**RE: Nuevo Atrisco
201 Unser Blvd. NW
Temporary C.O. - Approved
Engineer's Certification Date: 9/4/20
Engineer's Stamp Date: 12/3/19
Hydrology File: K10D058**

Based on the certification and a site visit on 9/11/20, this certification is approved for Temporary Certificate of Occupancy.

Please address the following items before the Permanent Certificate of Occupancy can be issued:

### GRADING AND DRAINAGE PLAN

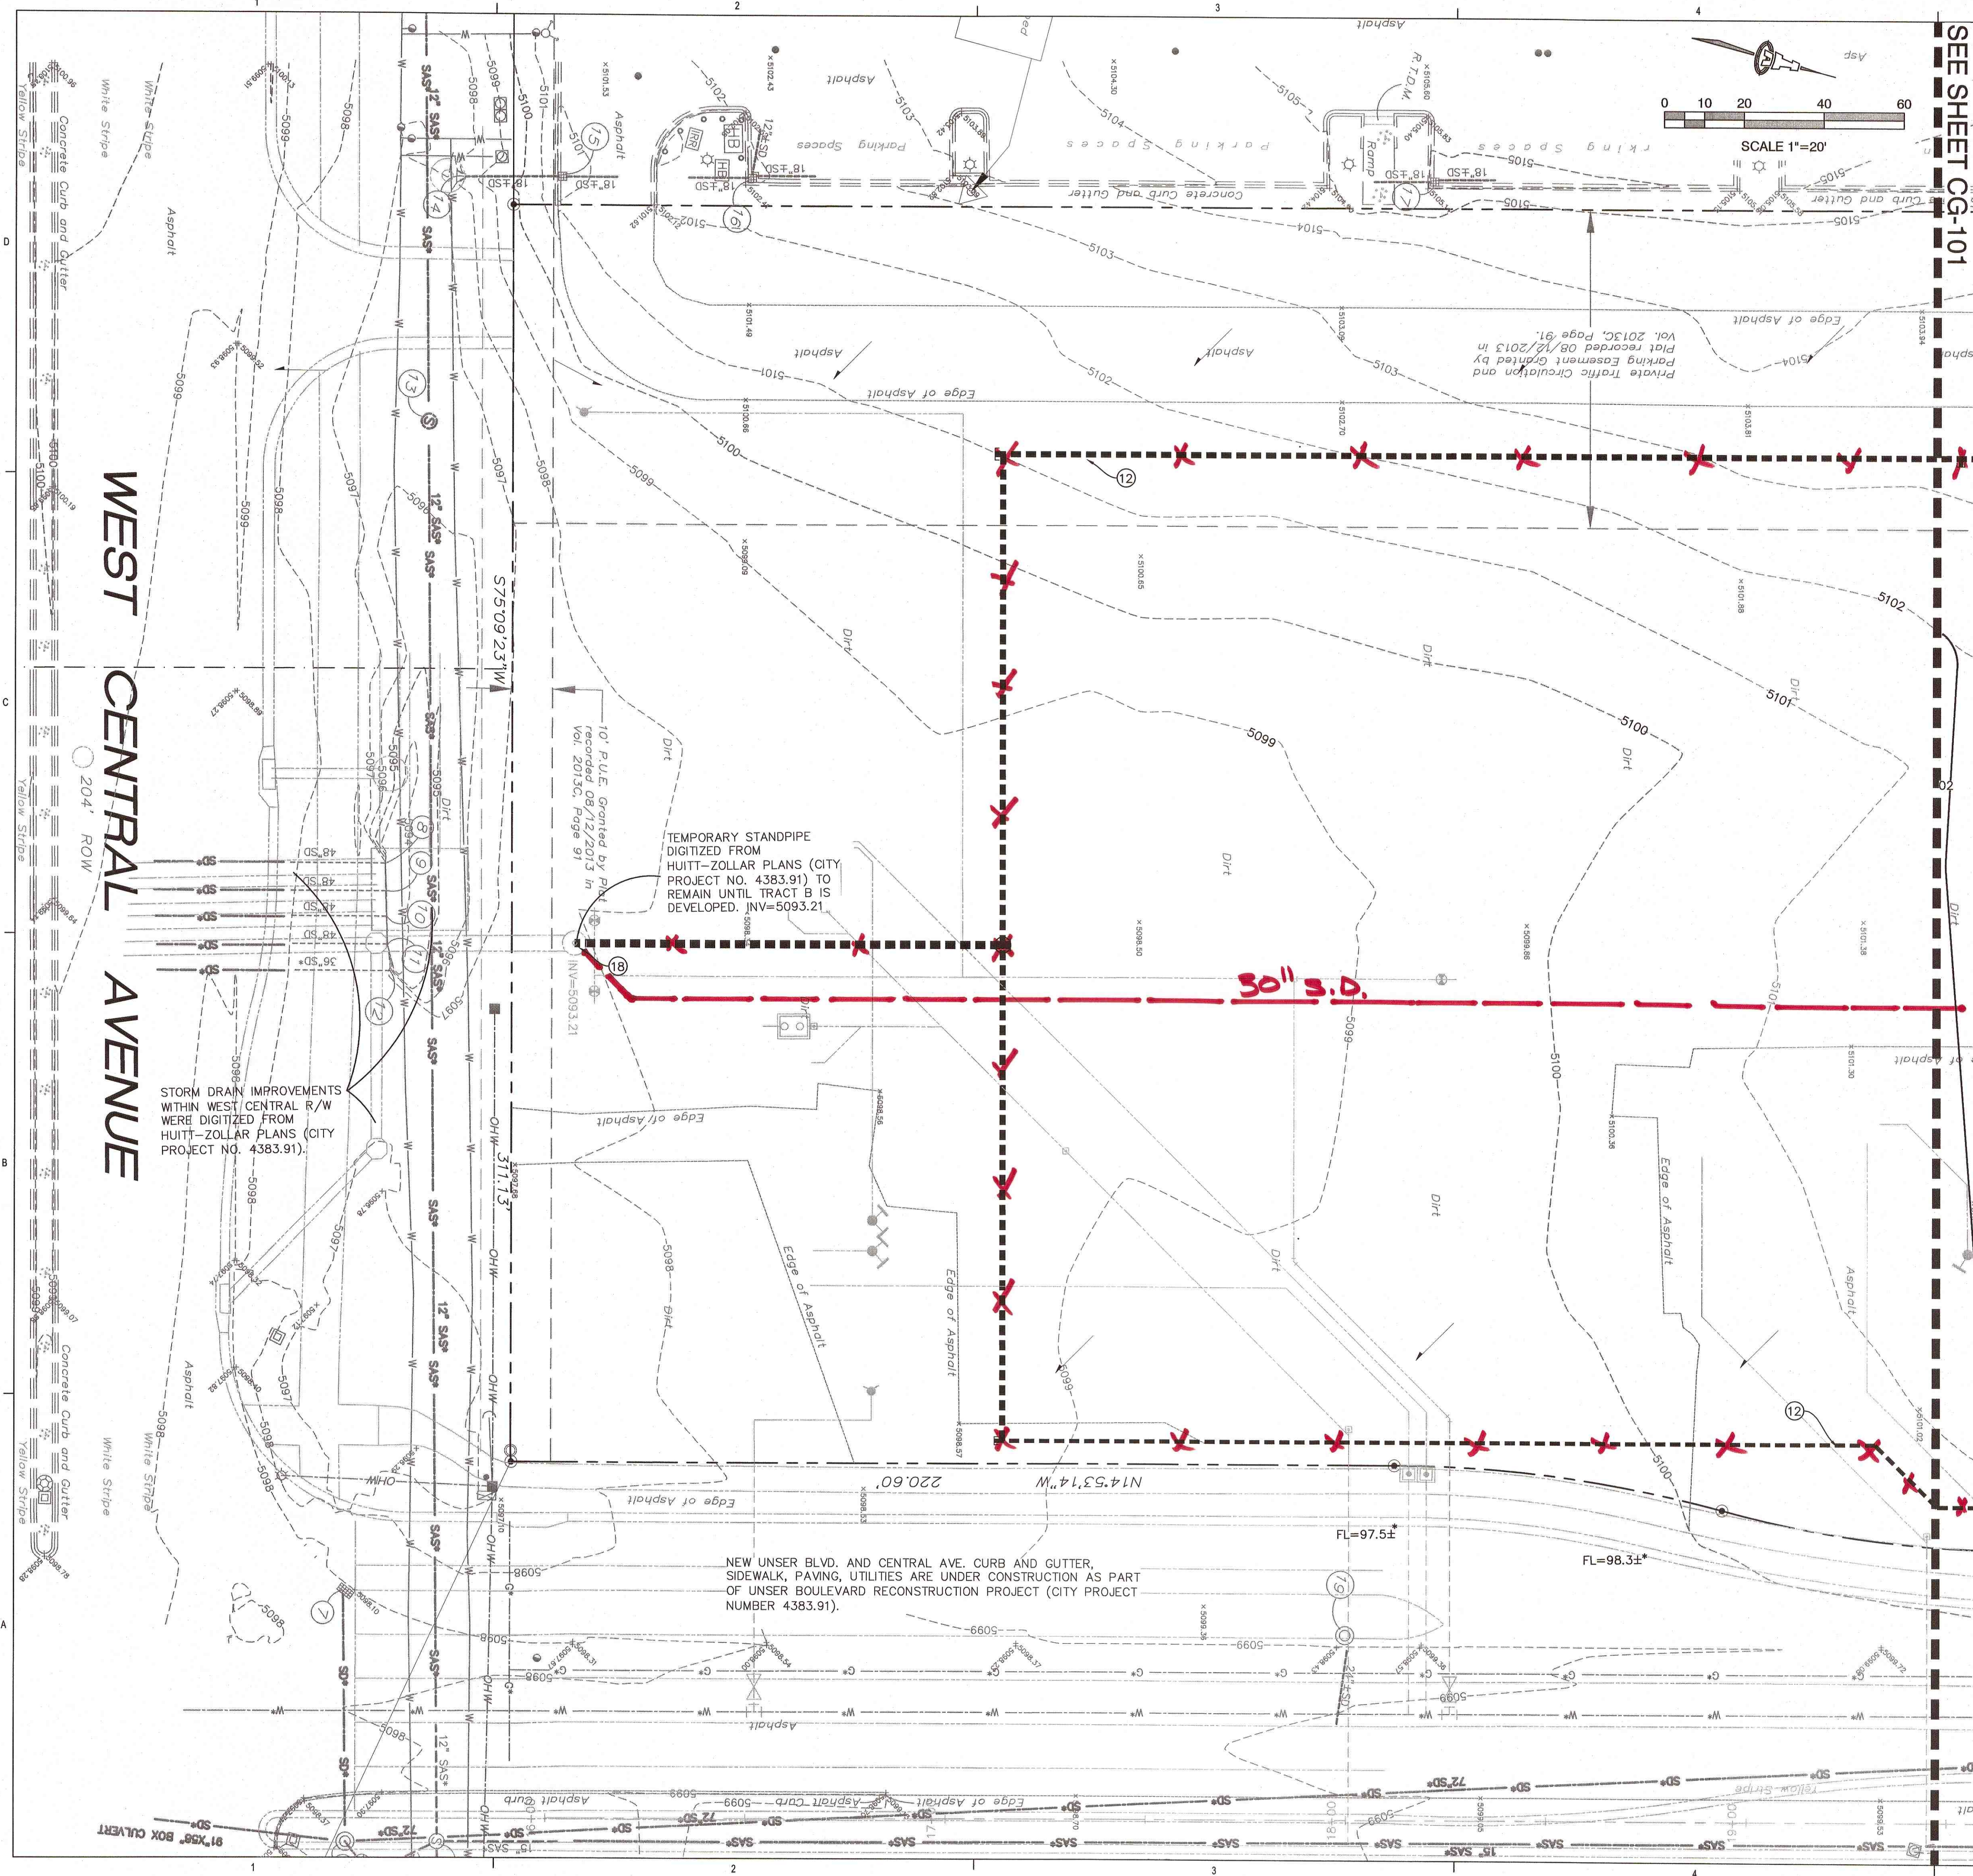
1. The building roof discharge points per keyed note 5 on the north side of the building were not evident.
2. The erosion control and rundowns from these roof discharge points on the north to the pond on the north side of the site were not in place.
